Our reference : DOC08/45512; FIL06/615  
Contact : Allison Treweek

**MP06\_0165 Proposed residential development, Manyana**

**ATTACHMENT A – DECC letter to DoP adequacy assessment MP06\_0165**

**EEC BOUNDARIES AND ISSUES FOR PART 3A PROPOSAL MP06\_0165 AT MANYANA**

TOTAL PROP SUBDIVISION

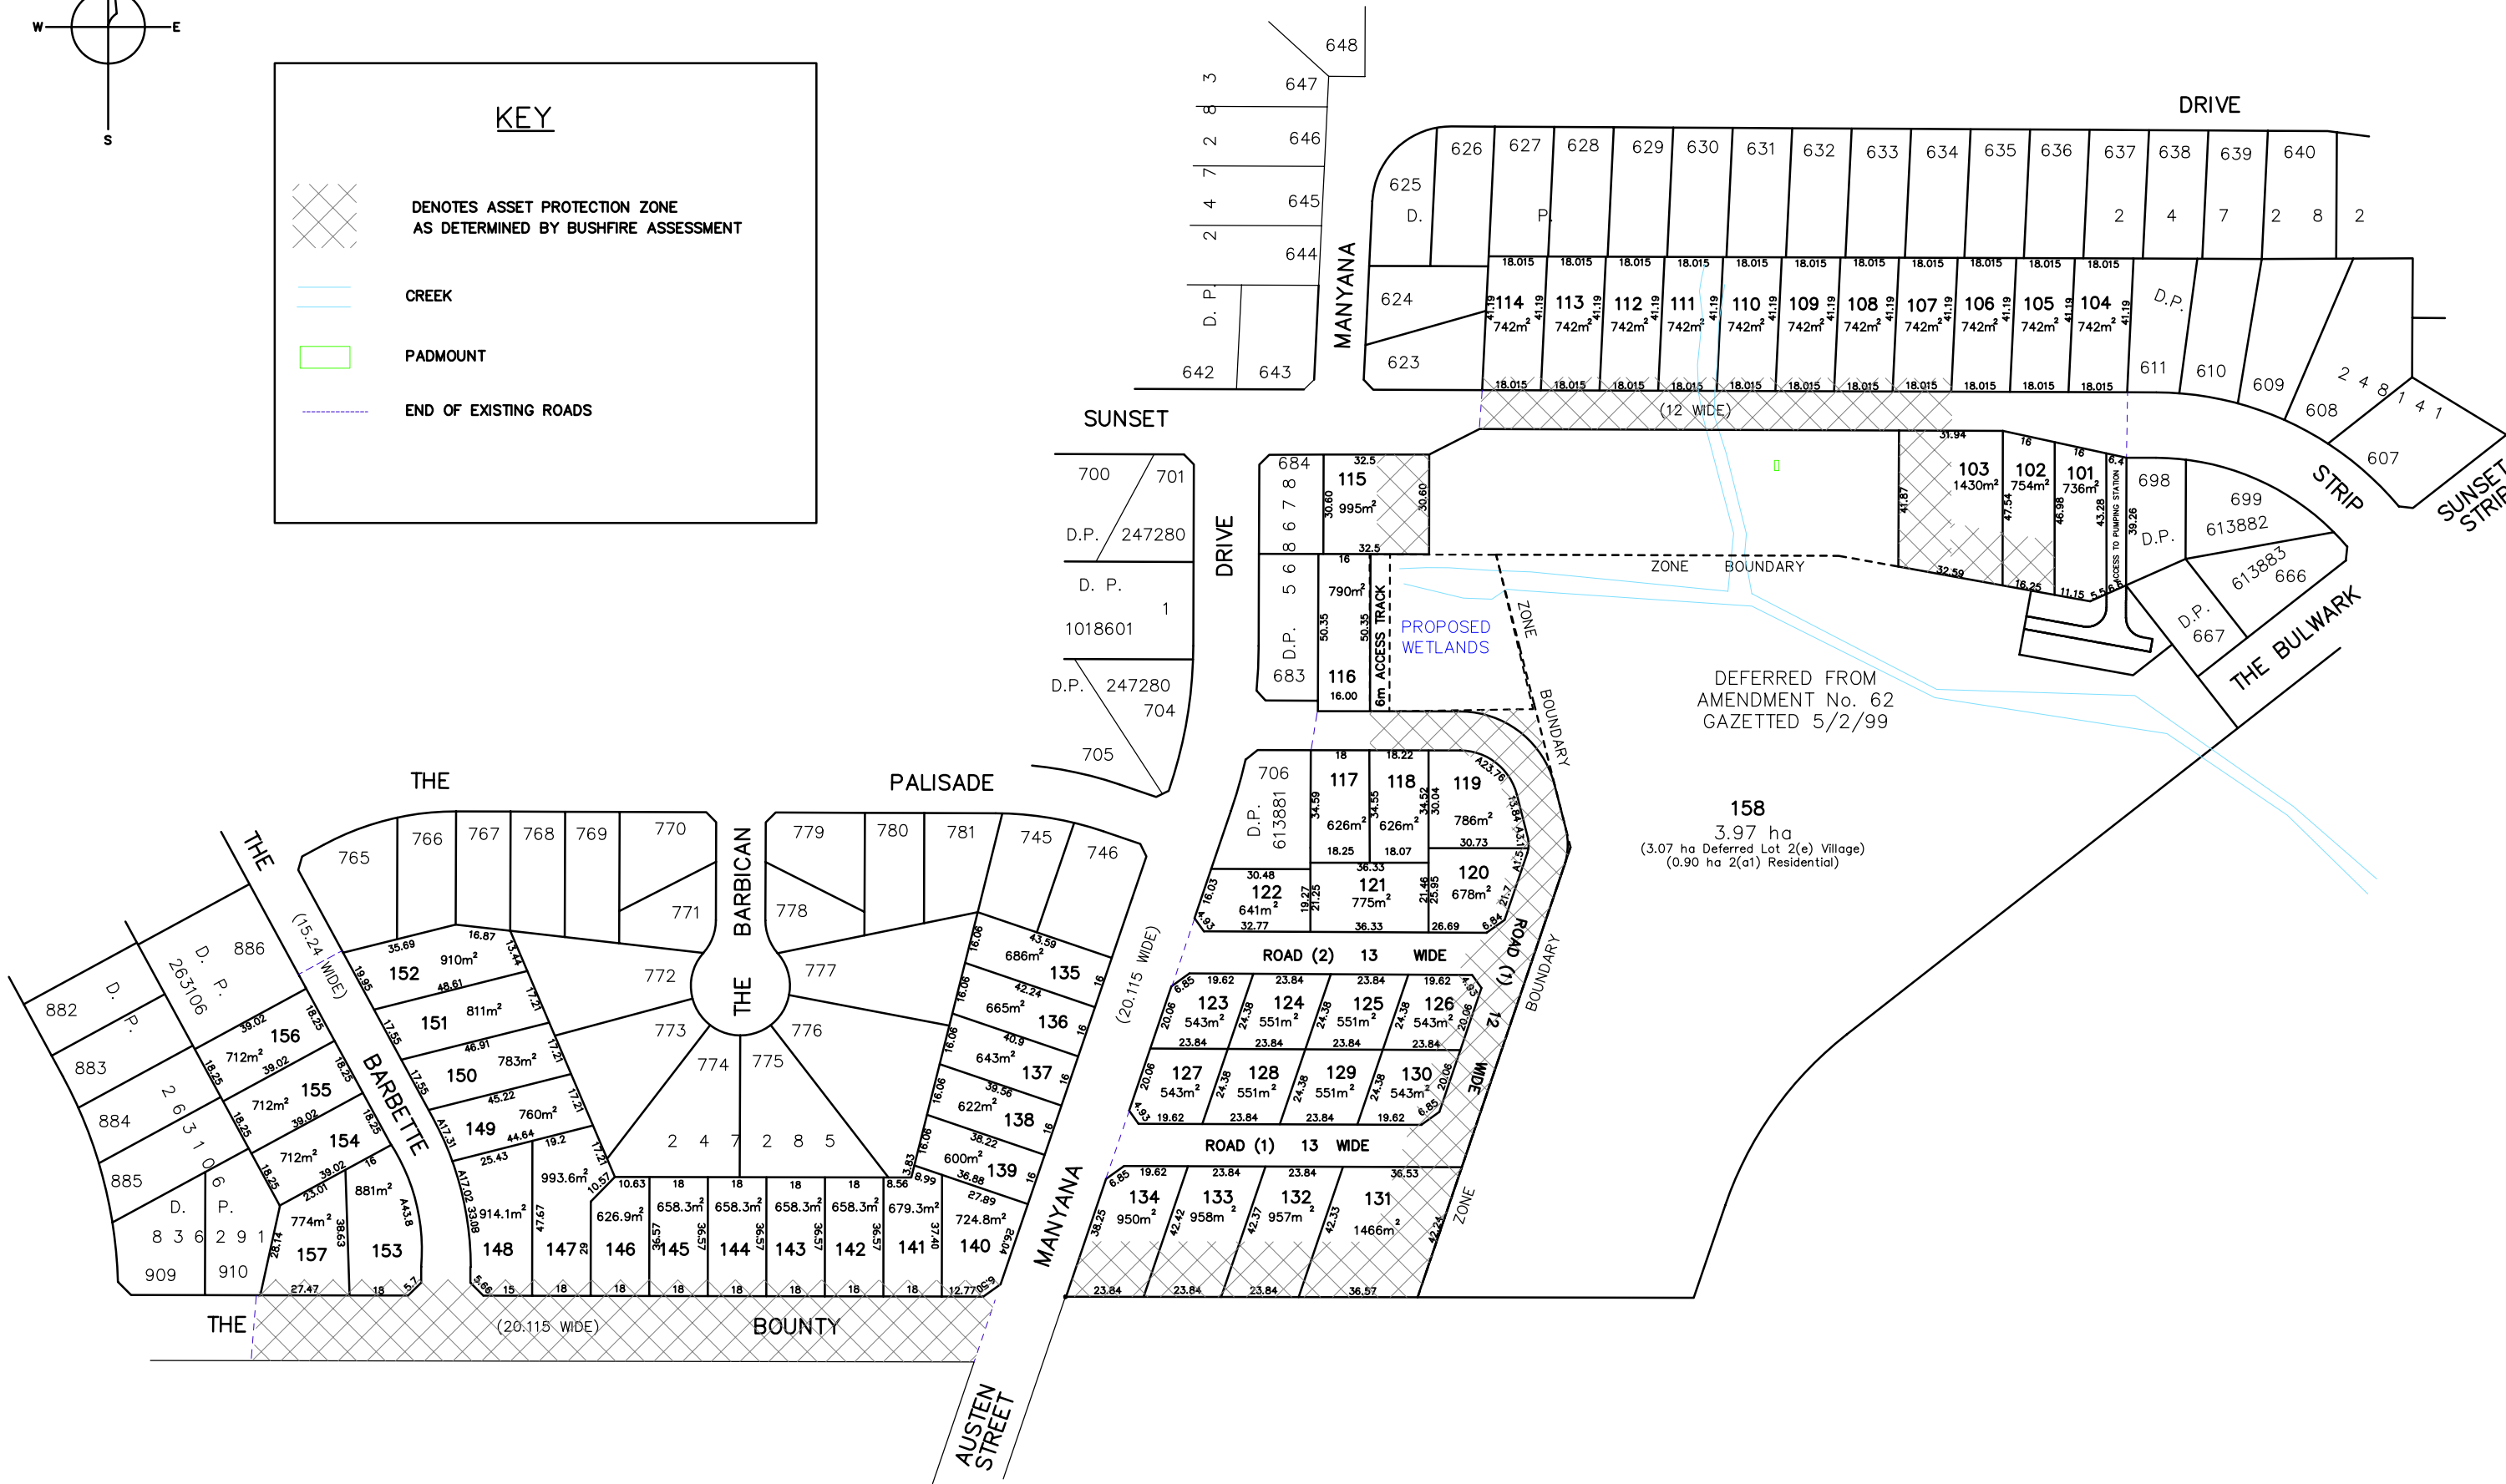
MAP LABEL	COMMENTS
A	<ul style="list-style-type: none"> <li>• Proposed artificial wetland lies wholly within SSF EEC – not appropriate if can be avoided</li> <li>• Proposed lots 115 and 116 do not provide for any buffer to the SSF EEC and their APZs are likely to encroach into it.</li> </ul>
B	<ul style="list-style-type: none"> <li>• This is not SSF EEC probably due to the presence of Banksia integrifolia. It may qualify as Bangalay Sand Forest EEC though.</li> <li>• Proposed lots 101, 102 and 103 do not provide for any buffer to the SSF EEC and their APZs are likely to encroach into it.</li> </ul>
C	<ul style="list-style-type: none"> <li>• There is a sharp transition from BSF EEC to non-EEC due to the abrupt change in substrate from beach sand to red clay.</li> <li>• The zone boundary easily allows for any minor variation in the EEC boundary to be protected.</li> <li>• It may be possible to extend the subdivision into the polygon labelled 4 by KMA if Council were to accept a rezoning in order to compensate for the loss of developable land elsewhere on the site, especially in the north.</li> </ul>

D	<ul style="list-style-type: none"> <li>• No threatened species issues in this area.</li> </ul>
E	<ul style="list-style-type: none"> <li>• Proposed lots 118, 119 and 120 encroach into the SSF EEC and their APZs are likely to encroach further into it..</li> <li>• Proposed lots 117 and 121 do not provide for any buffer to the SSF EEC and their APZs are likely to encroach into it.</li> </ul>
F	<ul style="list-style-type: none"> <li>• The vegetation mapping is incorrect and the SSF EEC extends to the northern and western boundaries as per the yellow line.</li> </ul>
G	<ul style="list-style-type: none"> <li>• The vegetation mapping is incorrect and the SSF EEC extends to the yellow line.</li> </ul>

Accordingly, DECC recommends that the EA should be revised to consider options for the proposal that avoid impact on the EEC (consistent with the 2005 *Draft Guidelines for Assessment of Impacts on Threatened Species Under Part 3A*). Where the proponent considers that the impact cannot be avoided, the EA should describe how impacts can be mitigated or offset, to achieve a "maintain or improve" outcome. With respect to offsets, DECC refers both the proponent and the Department of Planning to the "Principles for the use of biodiversity offsets in NSW" in Appendix II of the *Guidelines for Biodiversity Certification of Environmental Planning Instruments: Working Draft* (DECC 2007; ATTACHMENT B to this letter).
